January 9, 2018

**RE: Titan Presbyterian East Block – Sector Plan Map Amendment and Site Plan for Building Permit  
Project #1011115, 16EPC-40083/40084**

The purpose of this letter is to explain how we have addressed Conditions of Approval for the Sector Plan Map Amendment and the Site Development Plan for Building Permit for this project, located between Central Avenue and Copper Avenue, and Sycamore Street and the future realignment of Spruce Street. The project was approved by the Environmental Planning Commission (EPC) on February 10, 2017.

A1.10
SITE PLAN FOR BUILDING PERMIT

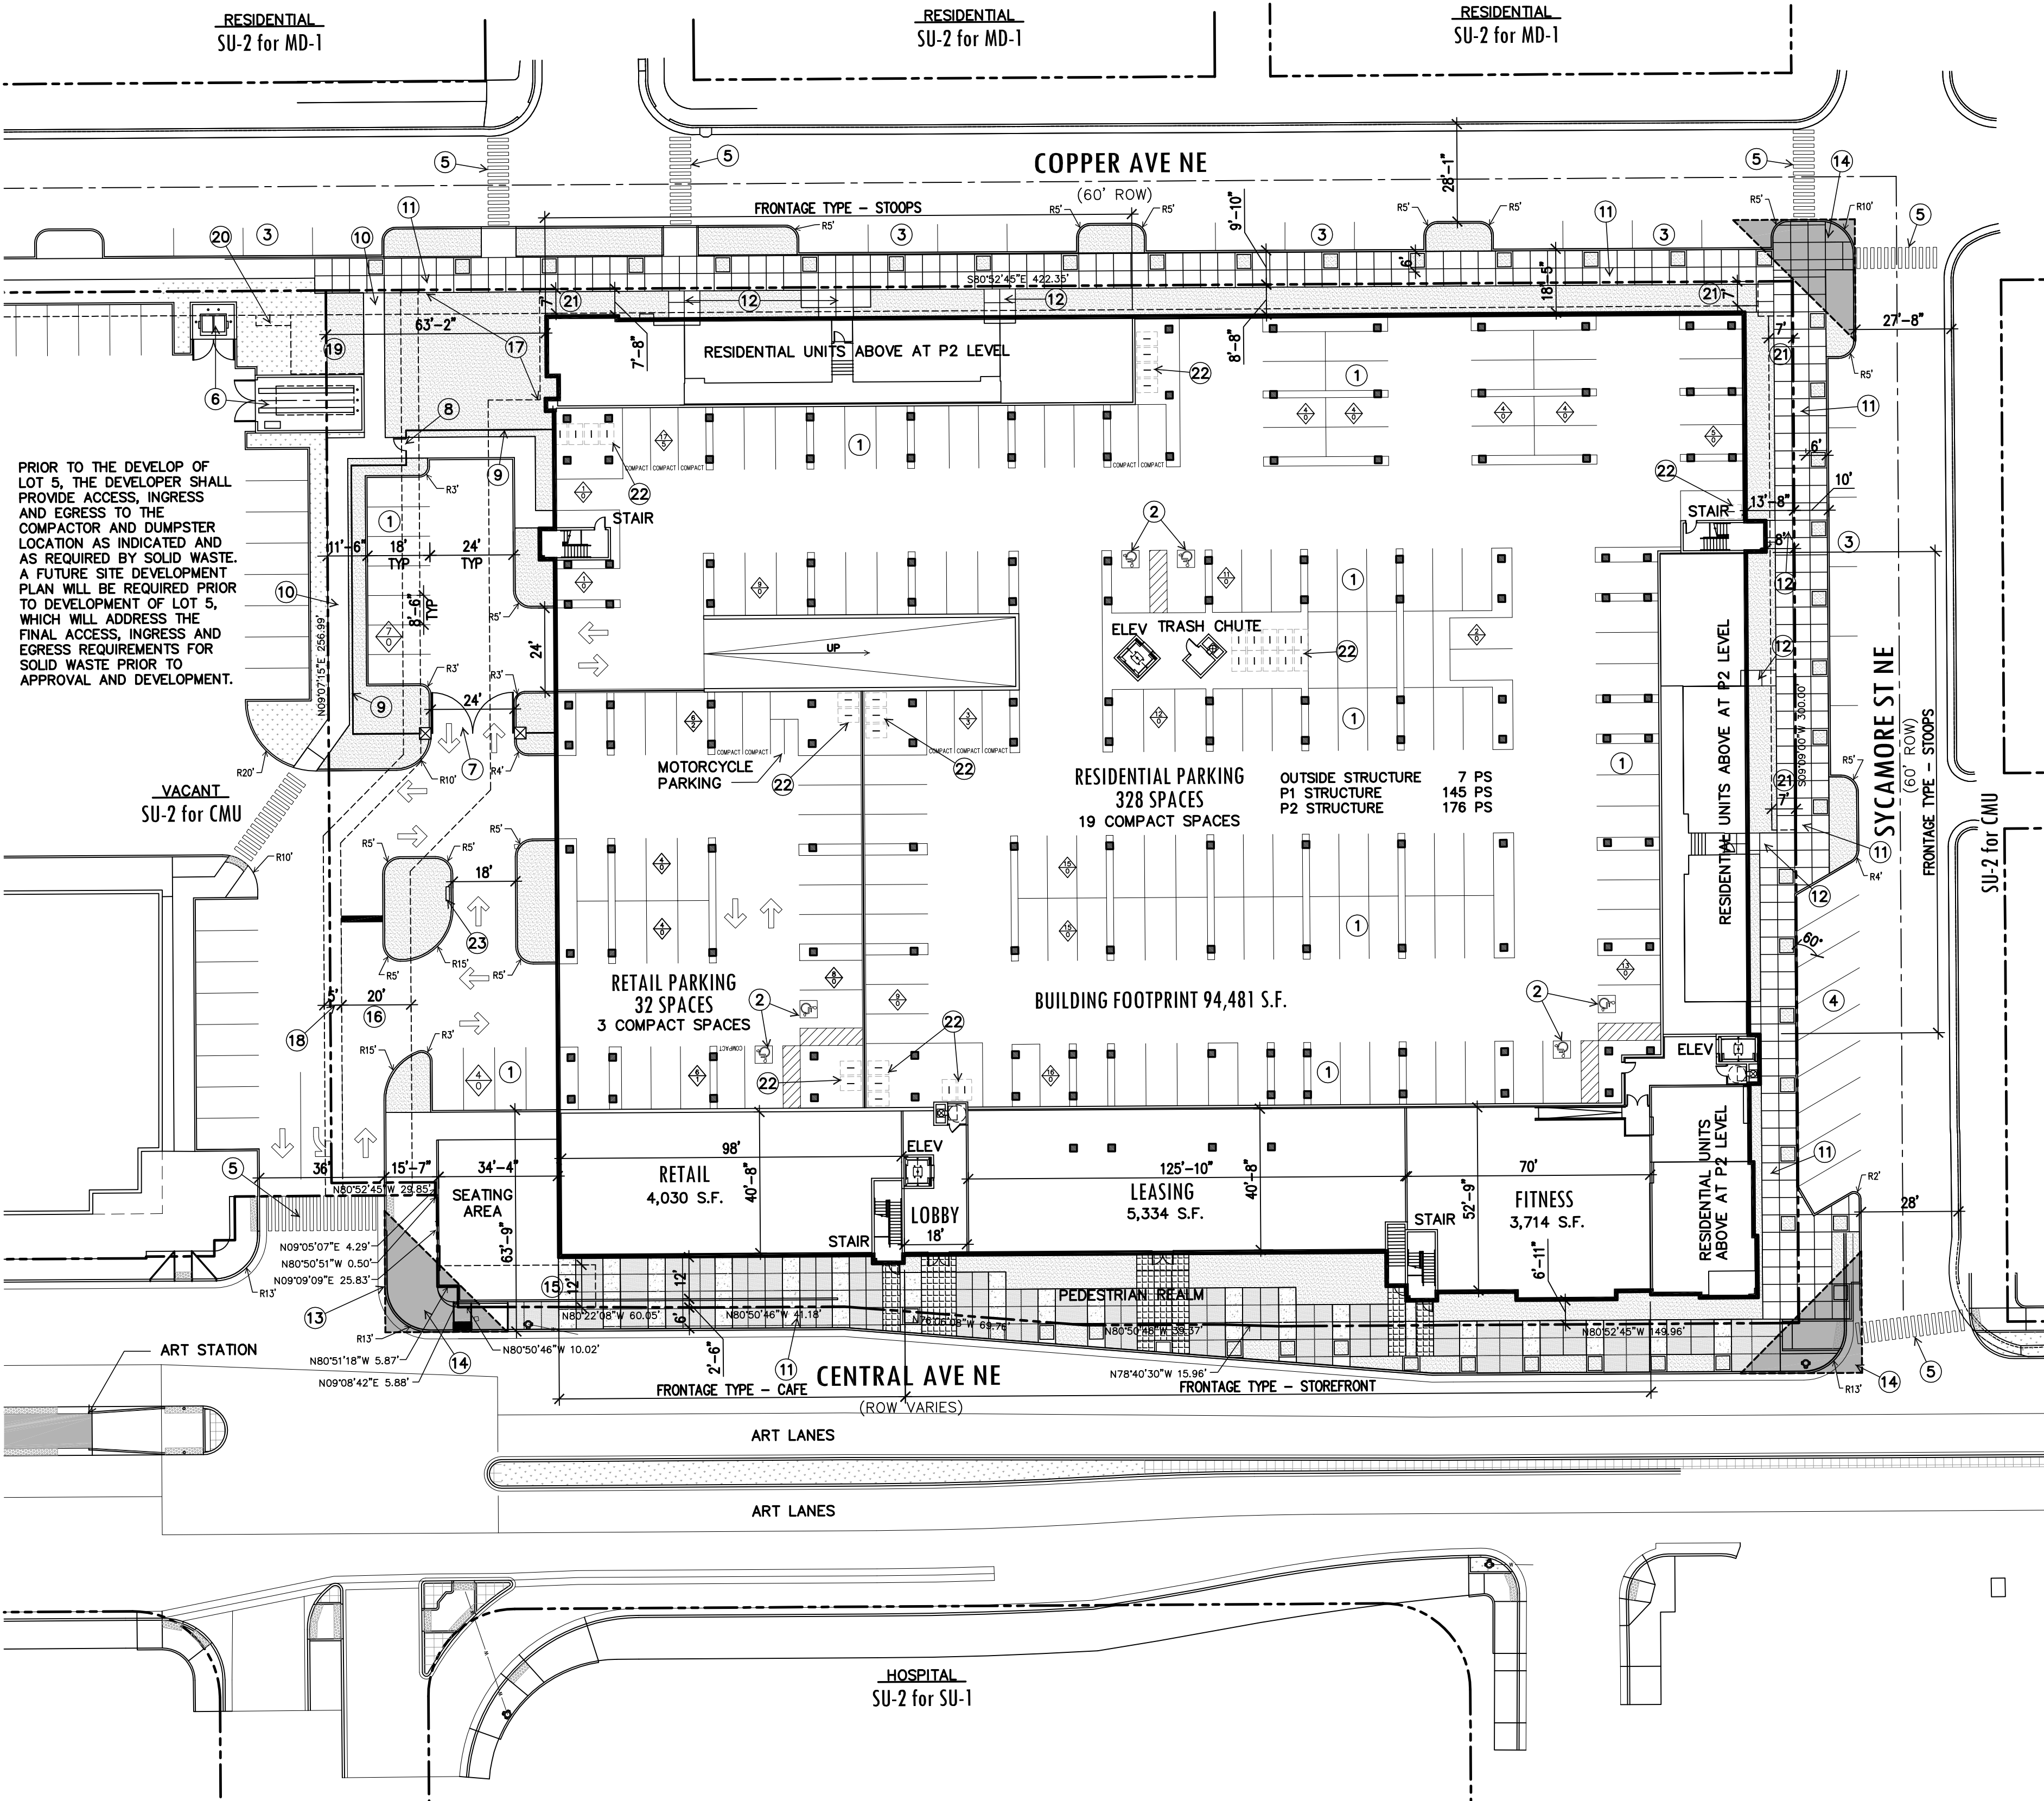
b. Under Development Data, Building Height, the allowed height bonus descriptor shall be updated to reflect the bonus being given for location along a "major transit corridor."

c. Under Development Data, Density, the descriptor of "DUNITS" shall be changed to either "Dwelling Units" or "DUs."

d. The number of parking spaces shown on the plans and the number in the parking space requirements table do not appear to match exactly and shall be updated accordingly.

4. General note #5 regarding lighting shall be updated to include specific references to the applicable code section 14-16-3-22(C)(6) where the requirements are found.

5. A location for the site directory map shown on sheet A1.21 (3 of 13) shall be identified on the site plan.

6. The site plan, building floor plans, and landscape plan shall be updated to ensure all direct access units and entryways along Copper Avenue and Sycamore Street have a paved pedestrian connection to the adjacent sidewalk. Specifically, one entry facing Sycamore Street appears to be blocked by landscaping, which should be corrected.

*The height bonus descriptor has been updated to reflect the bonus provided for location along a major transit corridor. The Zoning Code section that notes the building height bonus has been referenced: 14-16-3-22(A)(6)(b)(1)(c). Please see Sheet 1.*

*This correction has been made. Please see descriptor that has been updated to "Dwelling Units" on Sheet 1.*

*This correction has been made. The number of parking spaces provided on the plans reflect those indicated on the table. The parking table has also been updated to more clearly convey the required spaces and provided spaces. Please see Sheet 1.*

*Please see updated general note #5, Sheet 1 for reference to applicable lighting regulations.*

*The location of the site directory map has been identified as Keyed Note 23 on Sheet 1.*

*All entryways along Copper Avenue and Sycamore Street show paved pedestrian connections to the adjacent sidewalk. Modifications to the landscaping for an entry facing Sycamore Street has been updated based on this comment.*

A3.40

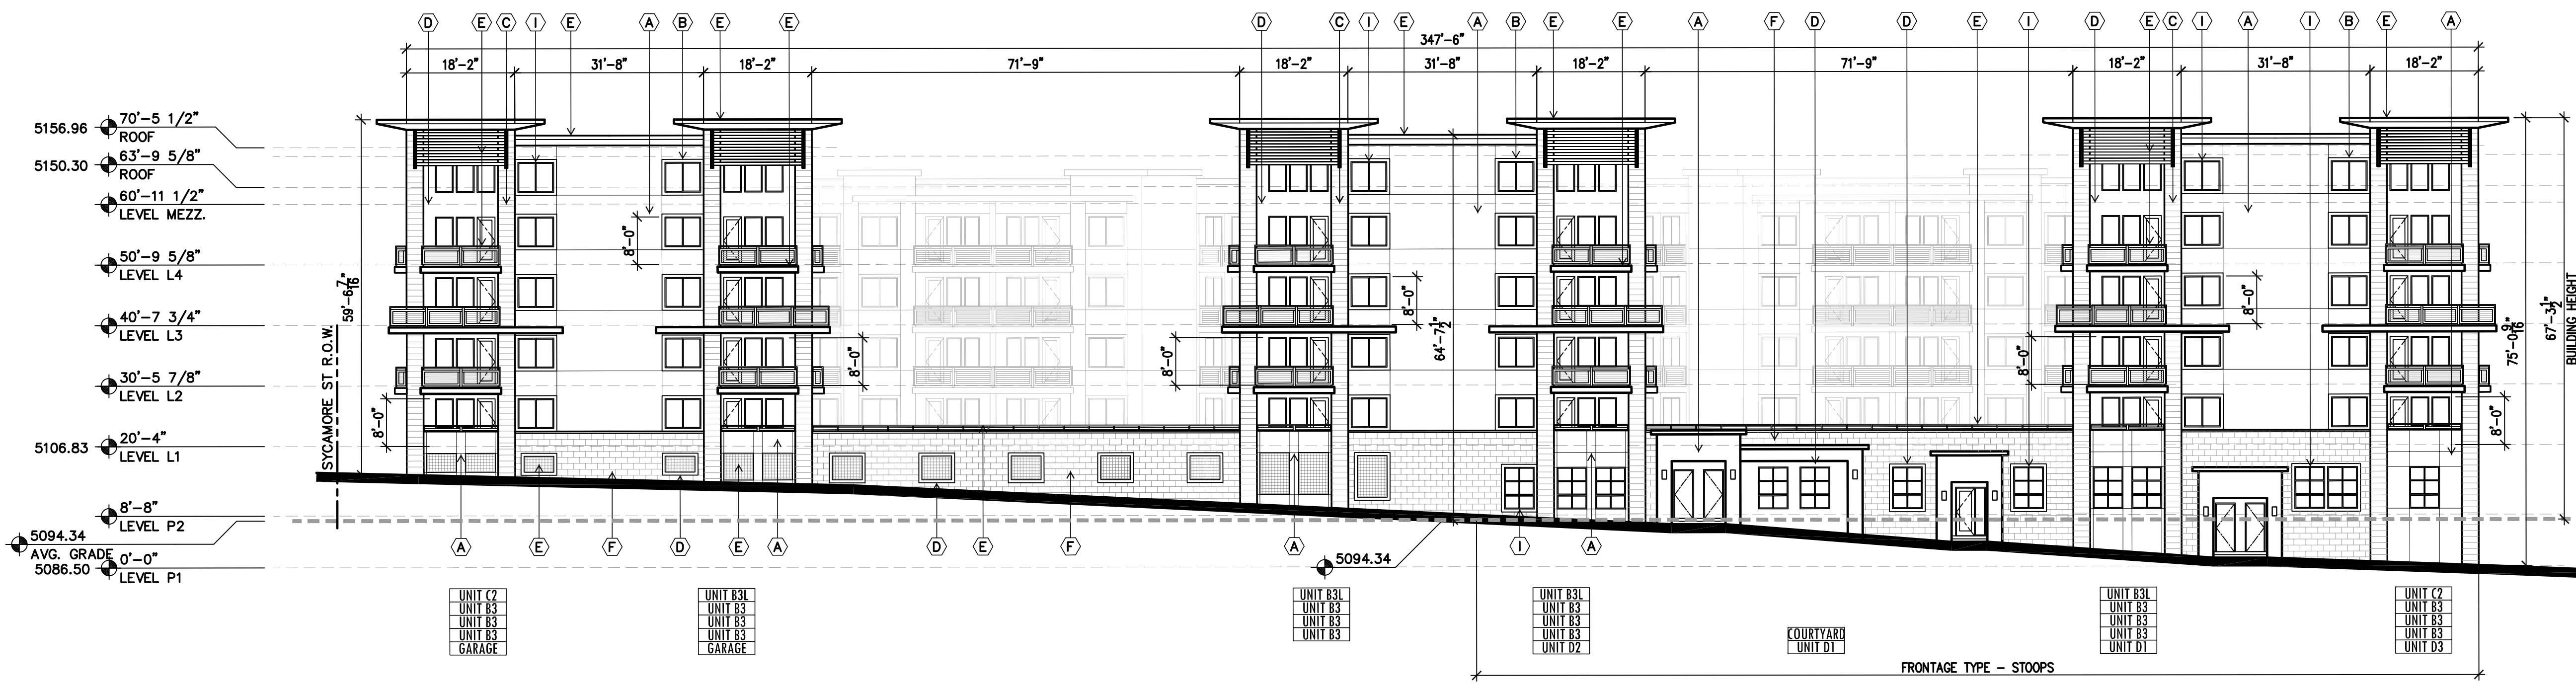
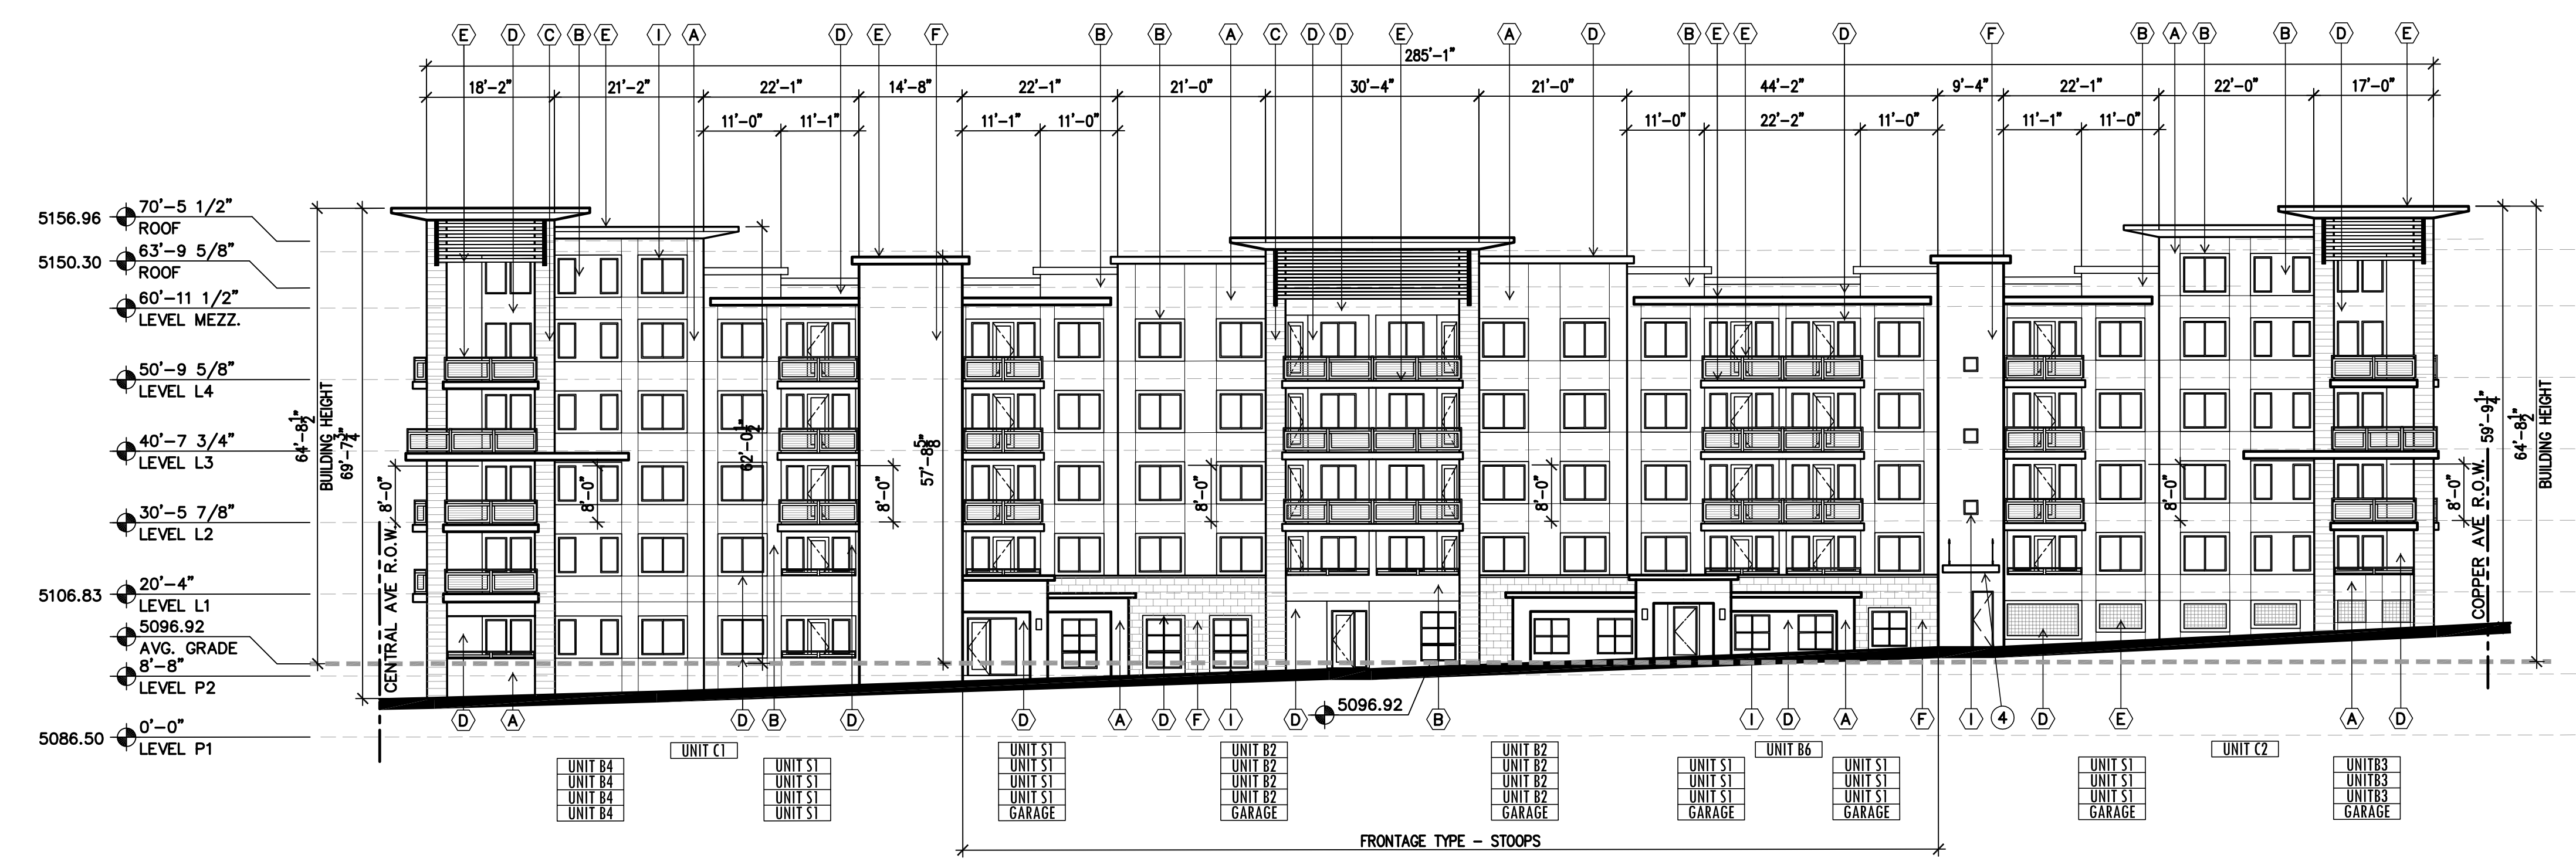
7. The signage note on the building elevation sheets shall be updated to clarify the code sections of the applicable requirements 14-16-3-22(B)(3)(n) and 14-16-3-22(C)(7).

8. The shading requirements note on the building elevations should be updated to include reference to the request for modification similar to what was noted on the site plan for the modification to building height.

*The signage note has been updated. Please see building elevation sheets A 3.40 and A 3.41, Note 1.*

*The shading requirements note has been updated. Please see building elevations A 3.40 and A 3.41, Shading Canopy Calculations, for reference to Zoning Code Section 14-16-3-22(A)(6)(b)(1).*

4 WEST ELEVATION
 SCALE: 1/16" = 1'-0"

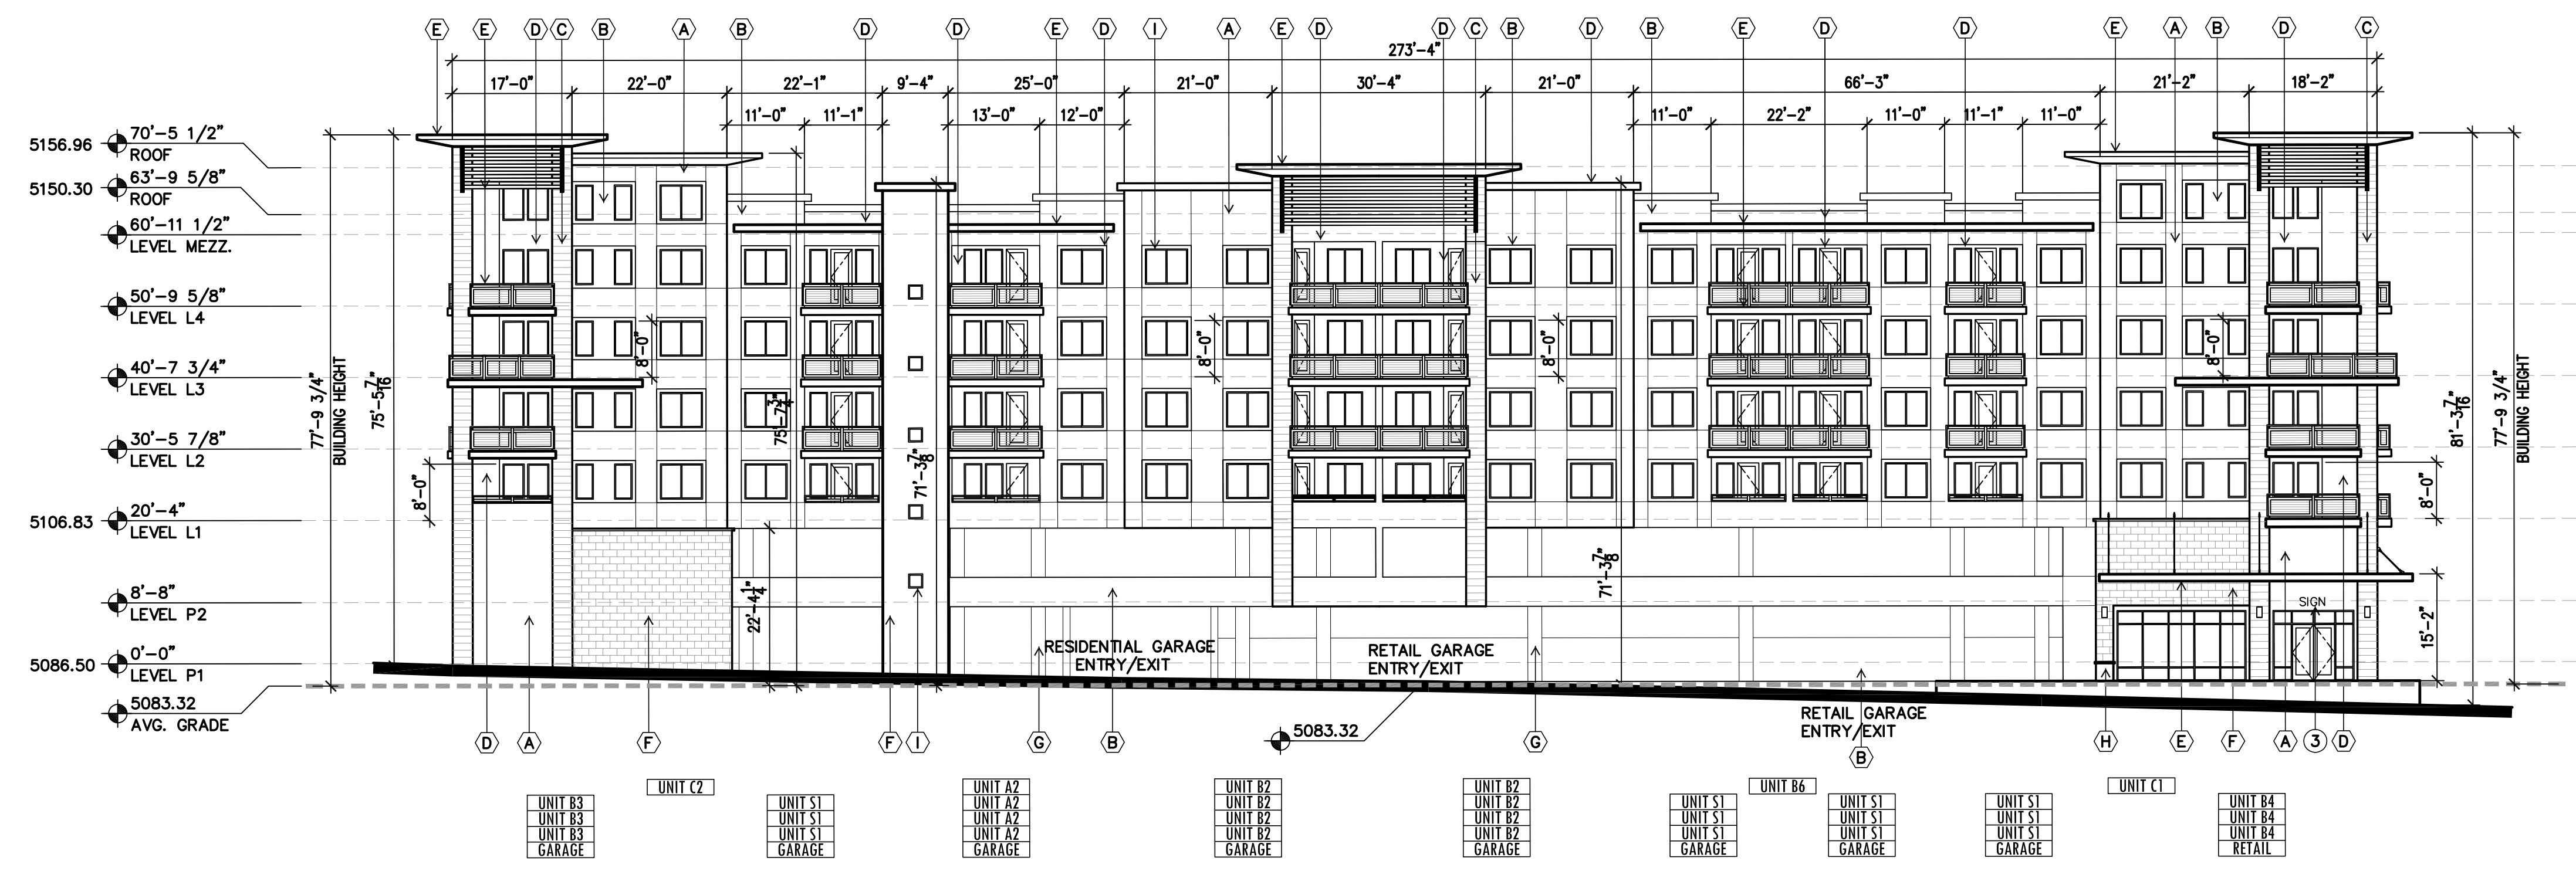
e. On the West Elevation, a keynote (#3) shall be added for the proposed sign location at the corner of the building.

*Keynote #3 has been added. See West Elevation, Sheet A3.41.*
